**RE: 96 Lawn Avenue**

**CBL: 132-I-005**

An evaluation of your porch and your building permit application fails to comply with the following sections of the 2003 International Residential Building Code of the of the City of Portland:

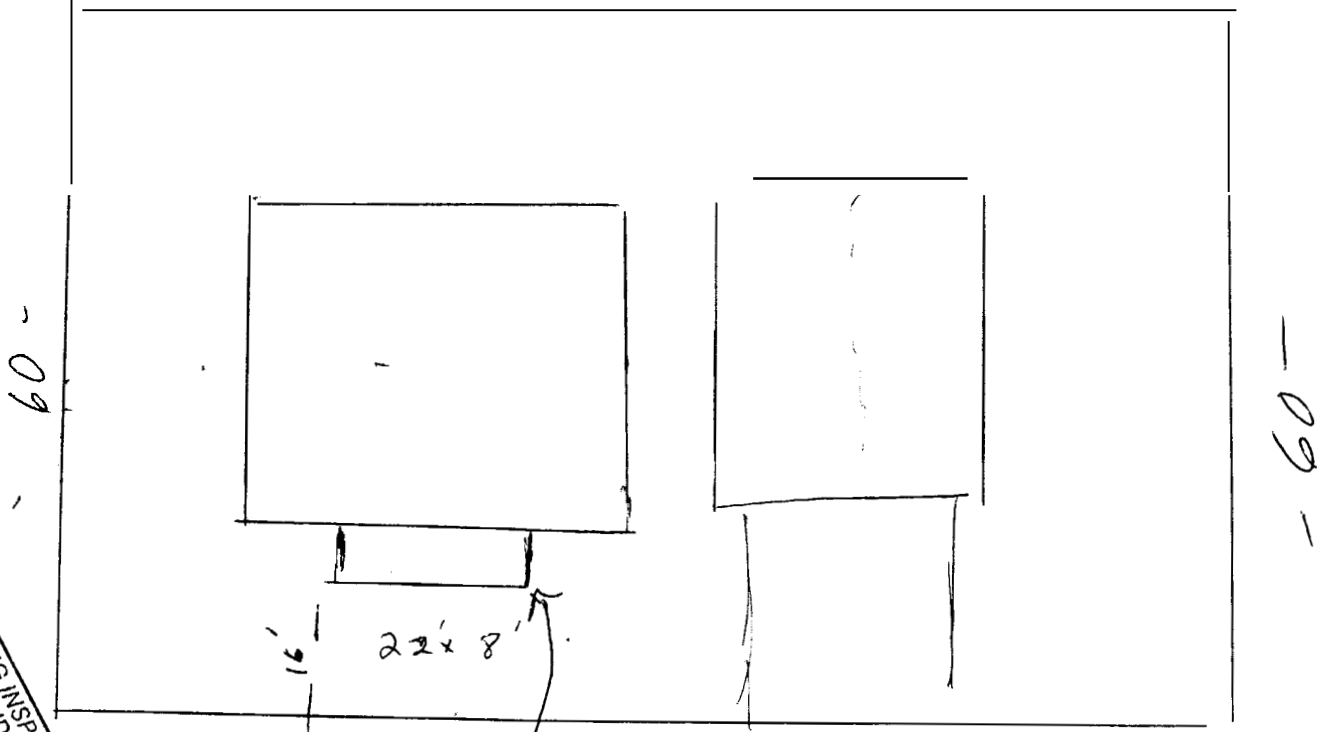
1. The floor girder is a 4"x 6" spanning 11'-0". The allowable span in Table R502.5(2) is 4'-6".
2. The guardrail system is 27 1/2" high. Section R312.1 requires 36" above the standing surface.
3. The floor joists are not bearing on joists hangers or a ledger strip. Section R502.6 requires a minimum of an 1 1/2" bearing.
4. The roof header size is not visible. The header is spanning 11'-0". Your application states 2" x 8"-s beam. There is a 1" x 4" trim wrapping this beam which indicates it is only 4" thick. The maximum allowable span from Table R502.5(1) for 2- 2"x 8" is 5'-11".
5. There are no guardrails on the open sides of the stairs. Section R312.1 states a minimum of a 36" high guardrail is required.
